Objection to Ribble Valley planning application 3/2023/0374 - Conversion of existing garage into a two-bedroom dwelling including new front porch, new access and vehicular parking for 41 Dilworth Lane.

**Proposed Block Plan**  
**Location Plan**  
DATE 03.02.2023

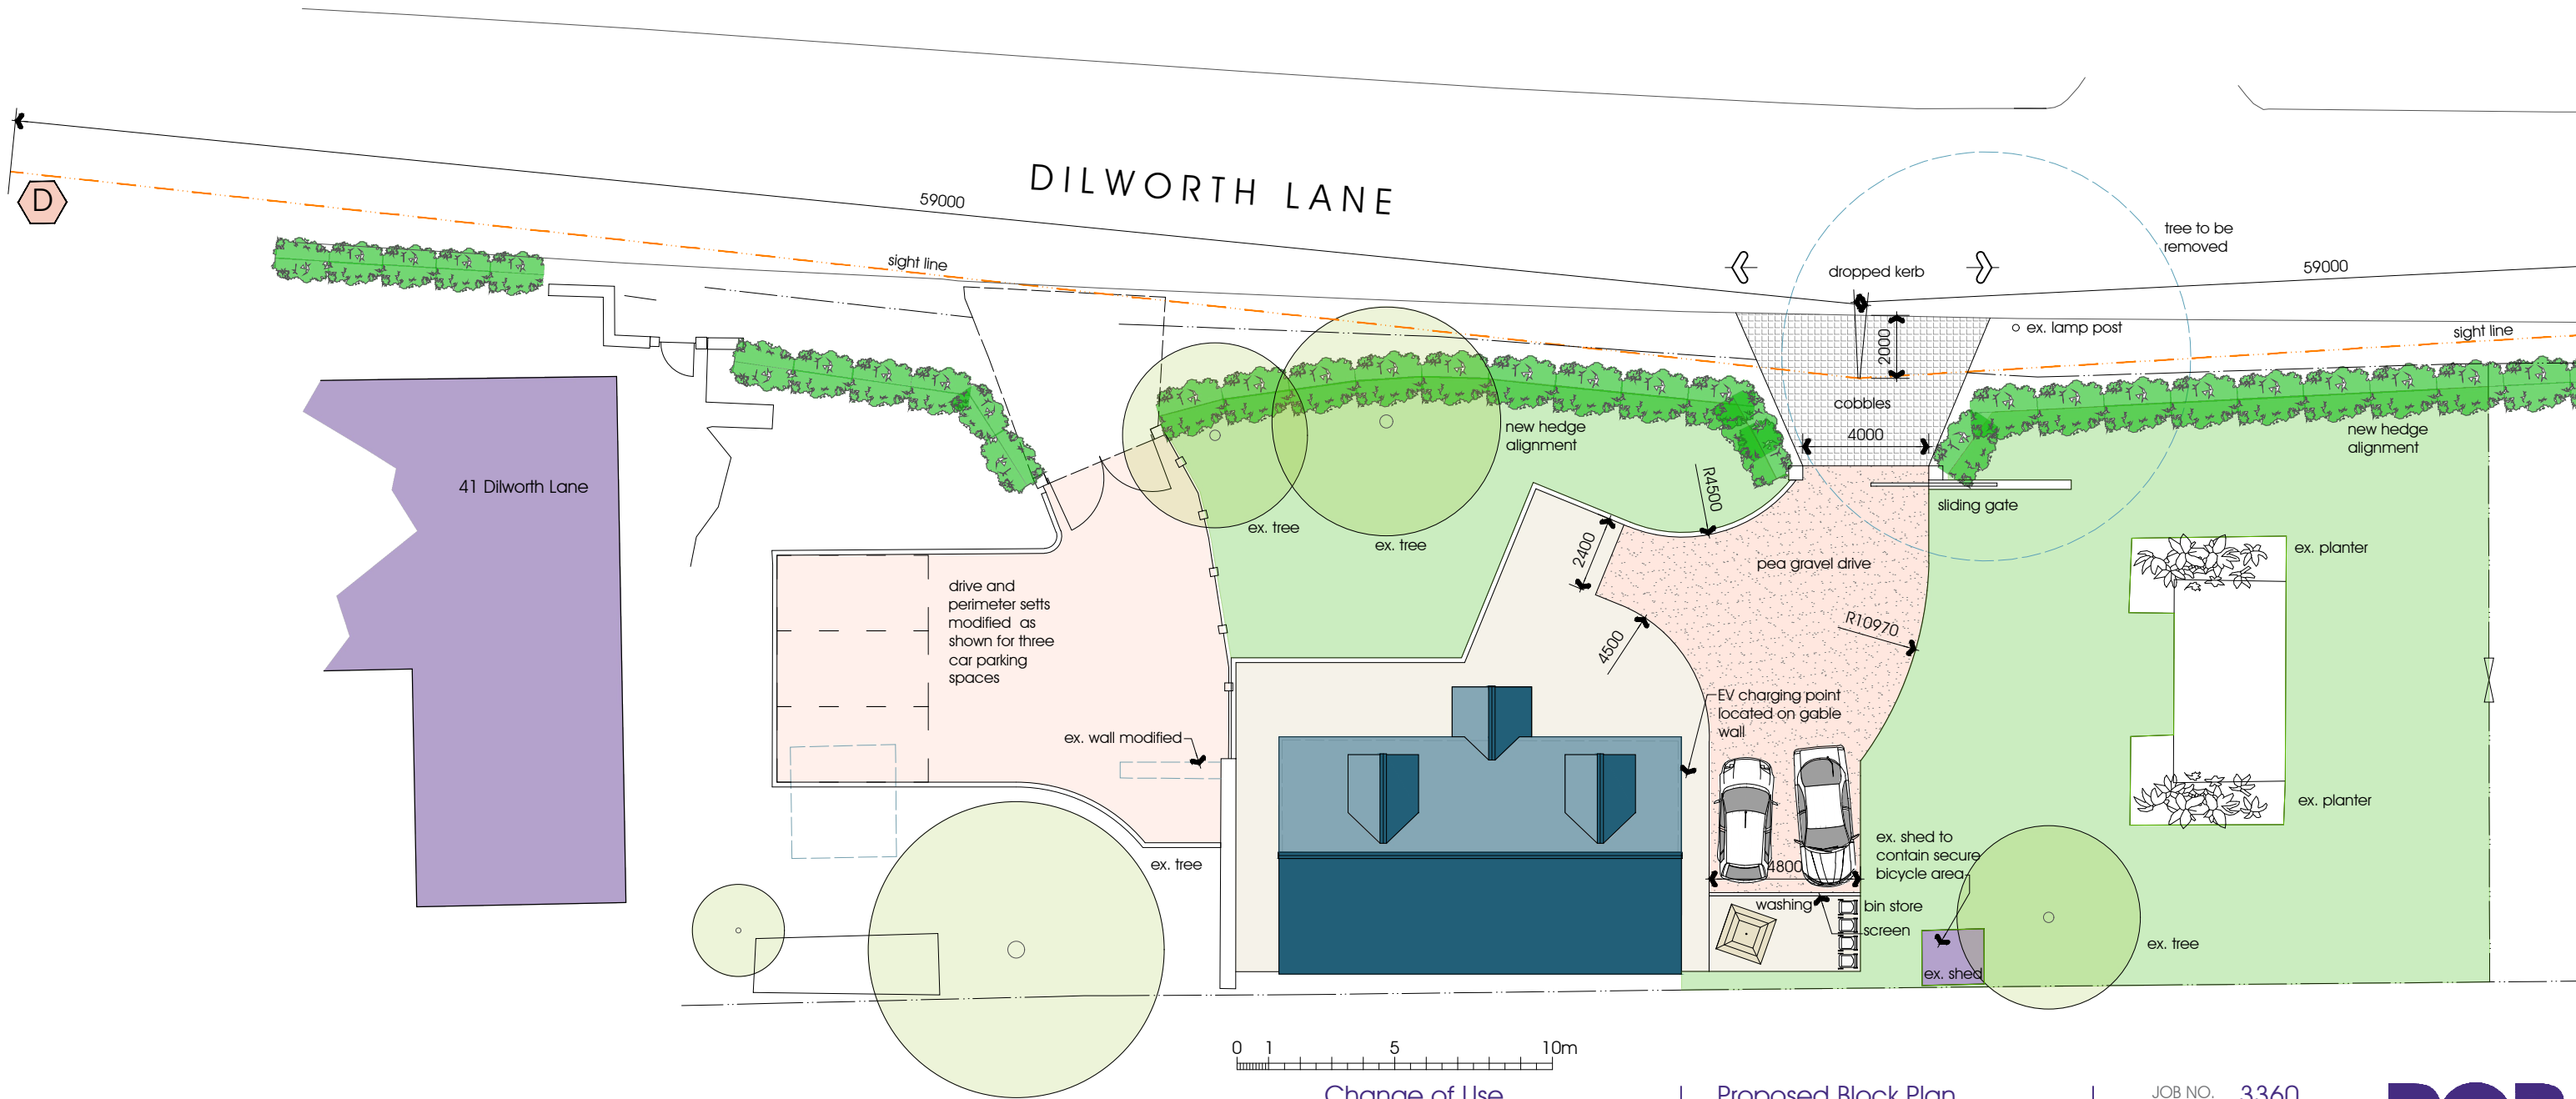
The proposed dwelling house is too close to the boundary and has no back garden. This contravenes current planning guidance. It poses an unacceptable positioning of living accommodation for the houses to the rear of the property and of the property itself.

This site is quite small and together with number 41 and the new dwelling nearing completion in the easterly end of the garden, it is a site that is being over-developed. A previous planning application below (3/2015/1024) was refused on grounds which would similarly apply to this application.

Drawing Title:
BS5837 Plan

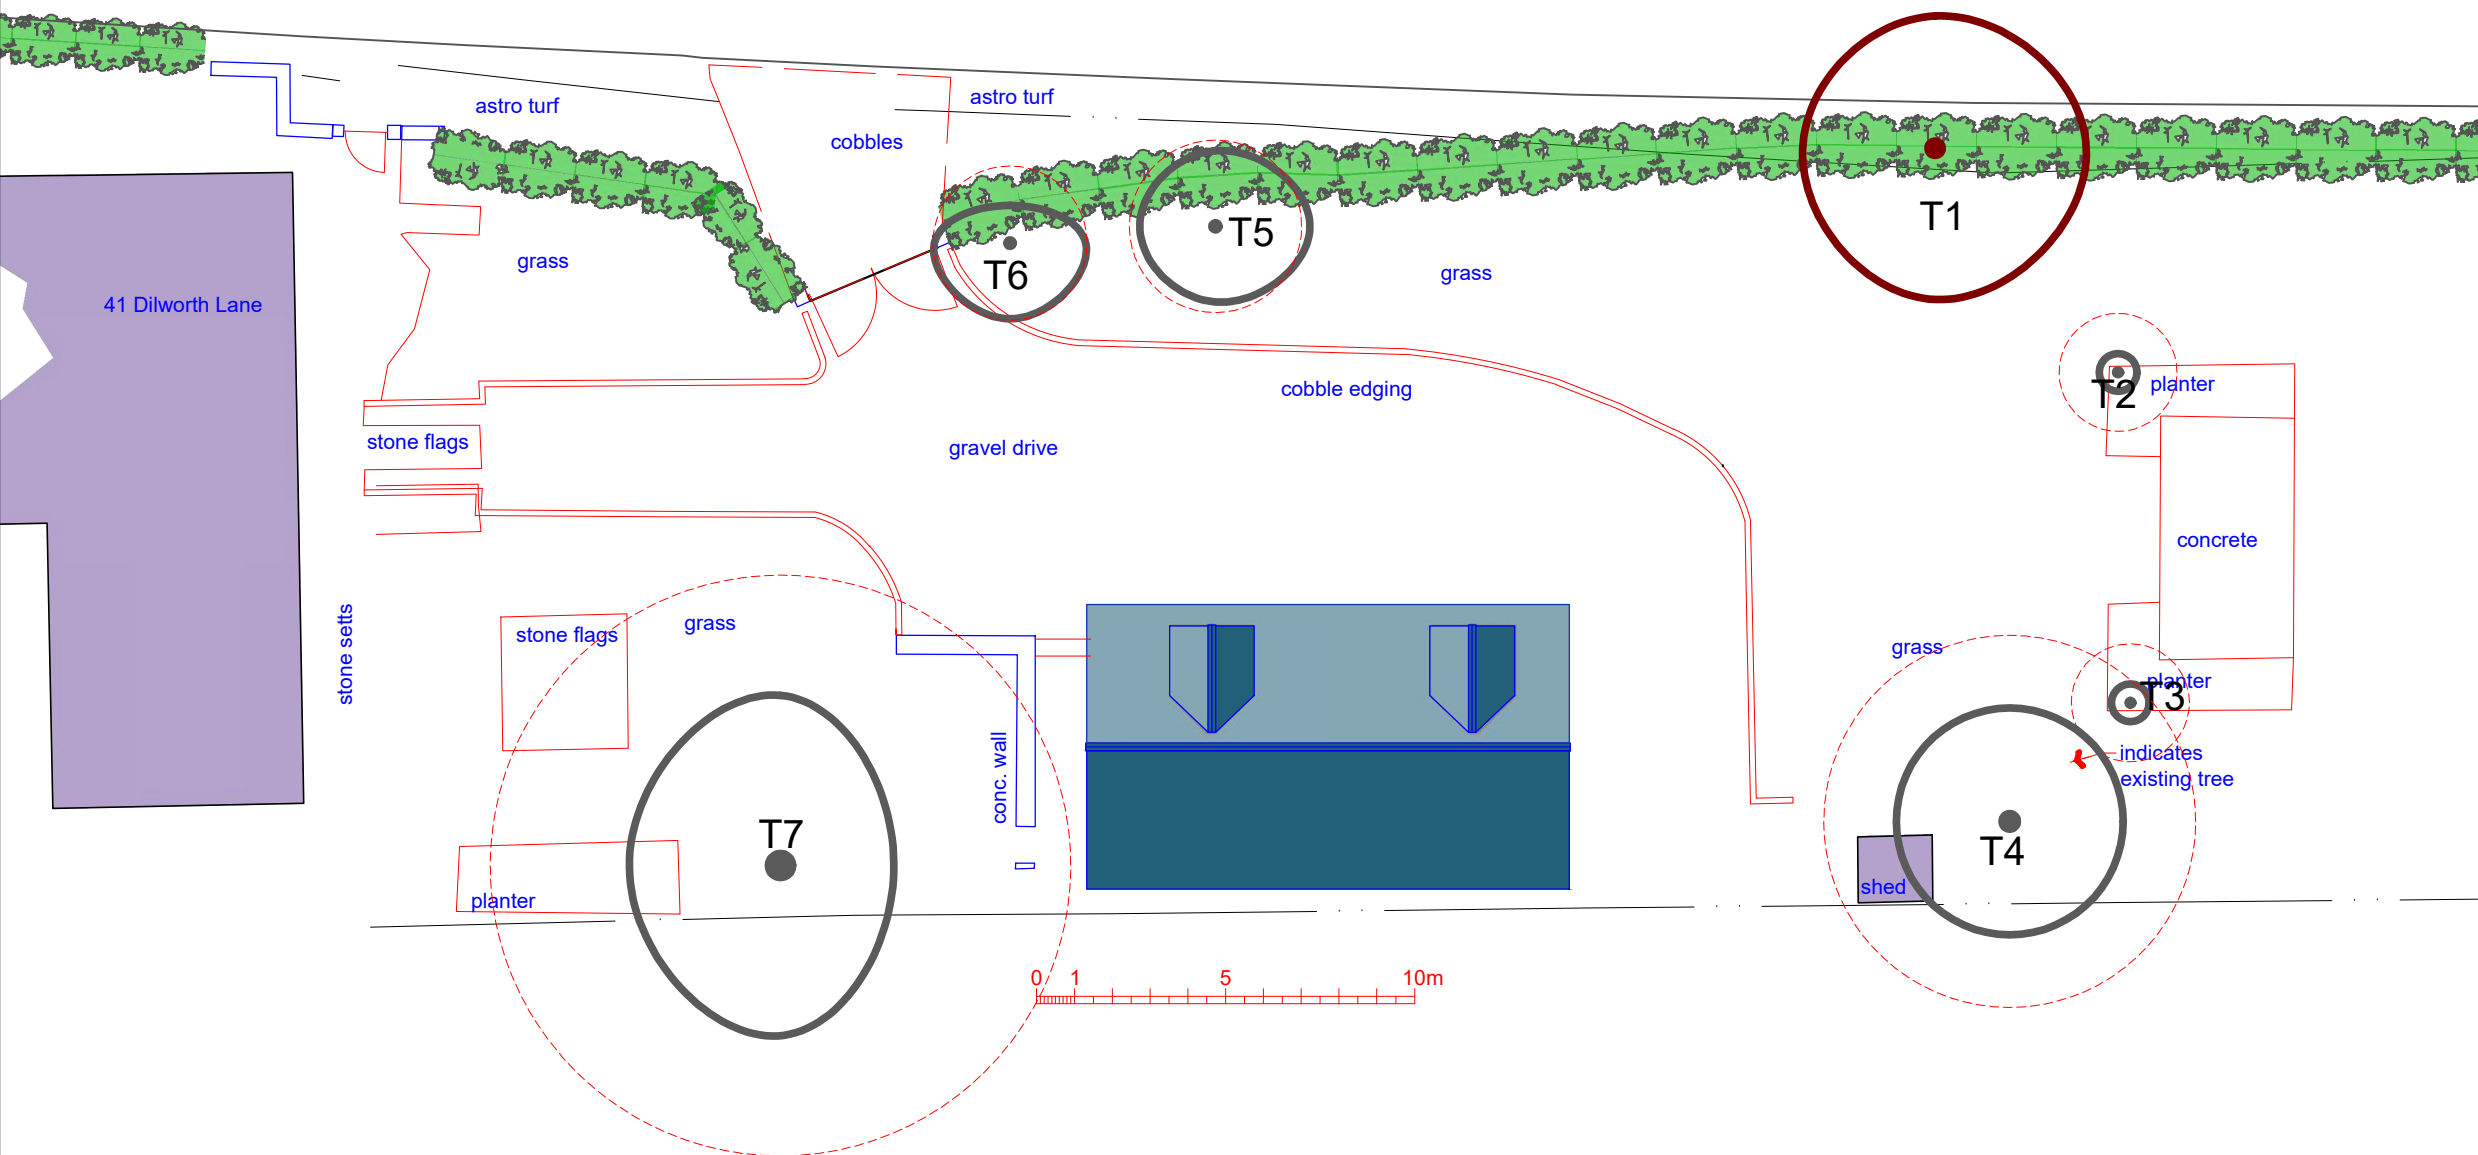
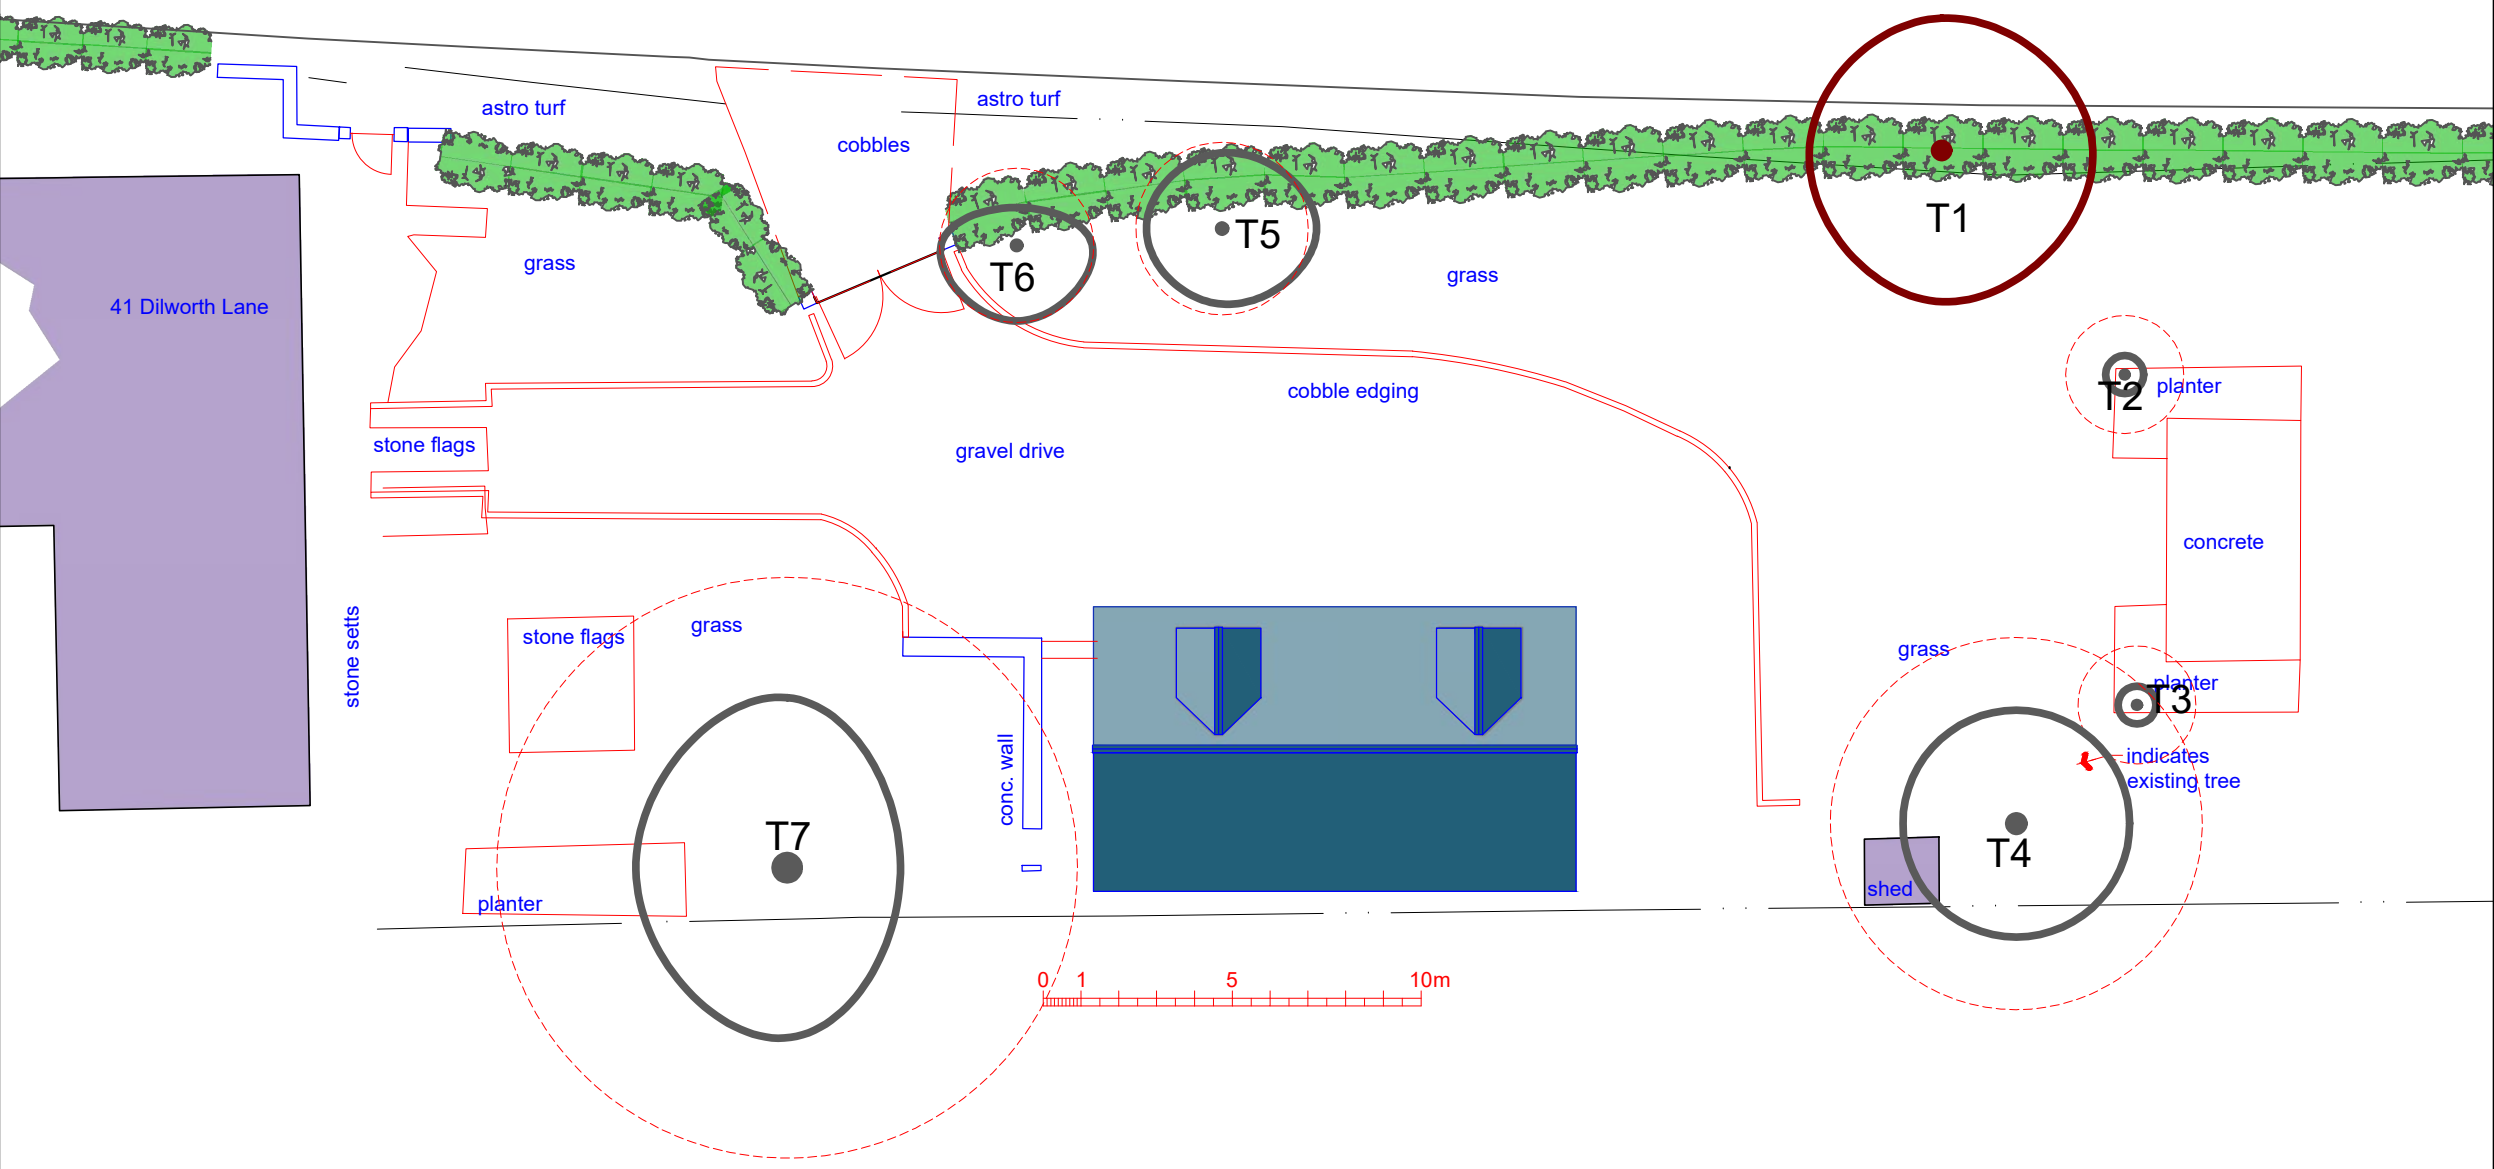
There is a TPO on site. The application requests that the Sycamore (T1) is removed to form the entrance. The applicant applied to remove this same tree last year (September 22) which was refused – please see below – specifically highlighted in blue. The tree does not appear to have declined in any significant way since the refusal in September 22 – please see attached photo.
